Your Ref: OWPC25491
Our Ref: AW/337/19/A 02-12-2019
Please ask for:
Amber Willard

Town & Country Planning (Control of Advertisement) (England) Regulations 2007 (as amended)

Installation of various signage.
The Ship Inn Aldwick Street Aldwick

ITEM 3 - ACM PANELS
ALUMINIUM COMPOSITE PANELS WITH DIGITALLY
PRINTED IMAGE TO FACE OF THE PANEL.

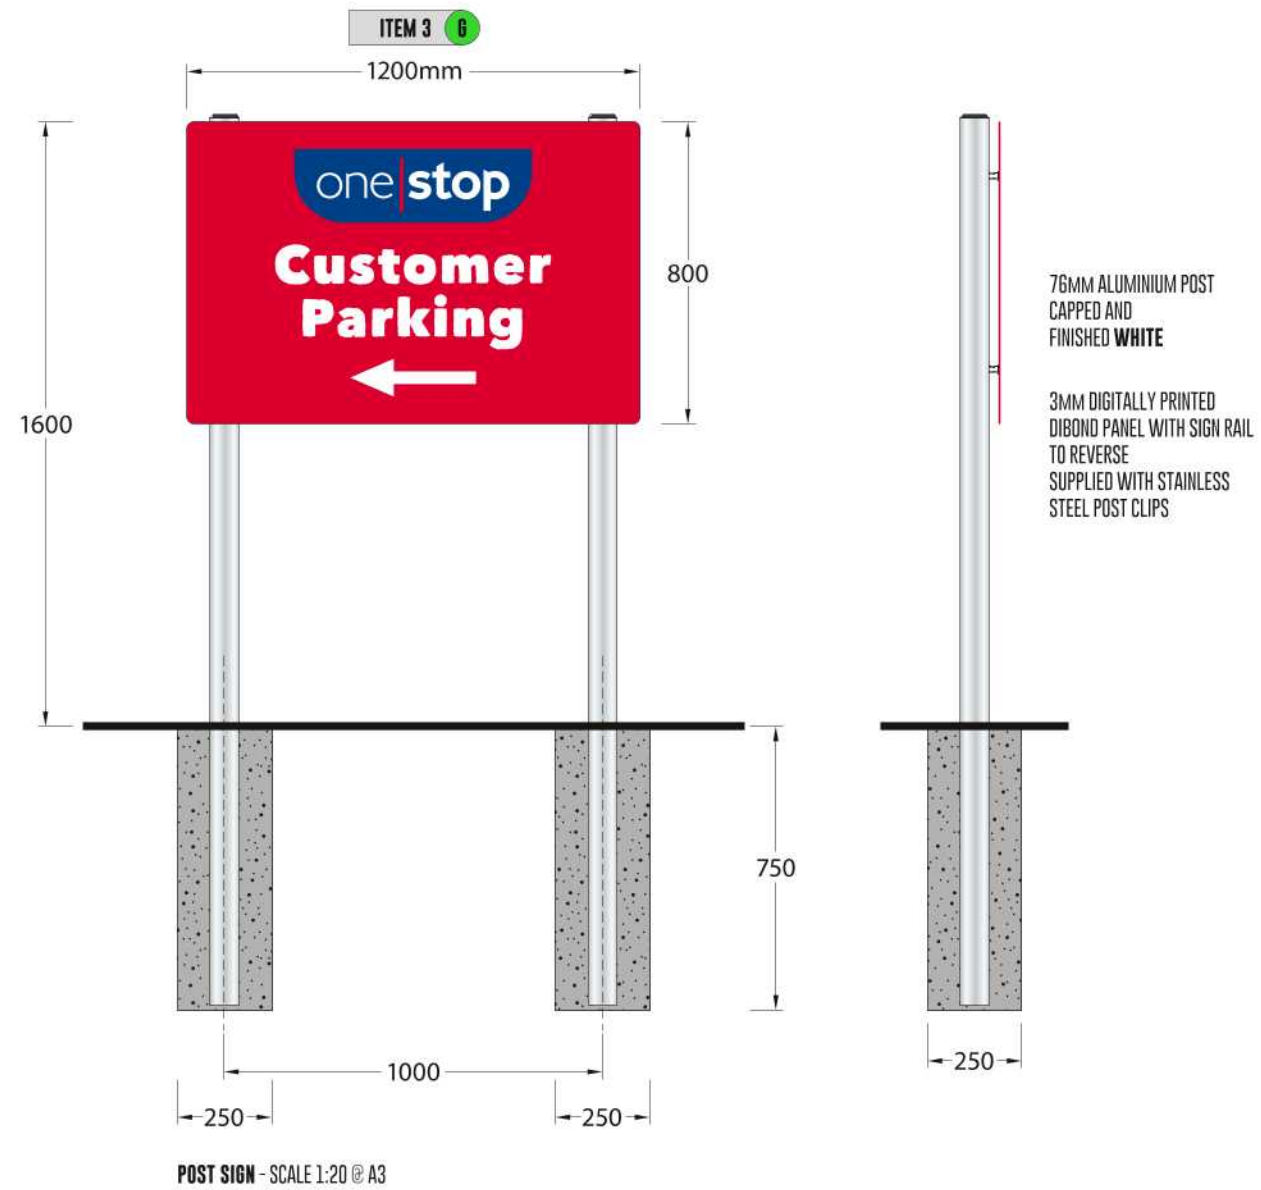
I object to this application on the grounds that the Aluminium Composite Material (ACM) panels contravene a proposal to specifically ban the use of metal composite panels in and on the external walls of ALL buildings.

The Aluminium Composite Material (ACM) panels are similar to those used as cladding on Grenfell Tower in London where 72 people died in a fire which spread too quickly through the building.

On this basis, this application should be refused because there are alternative non-combustible materials which could be used instead.
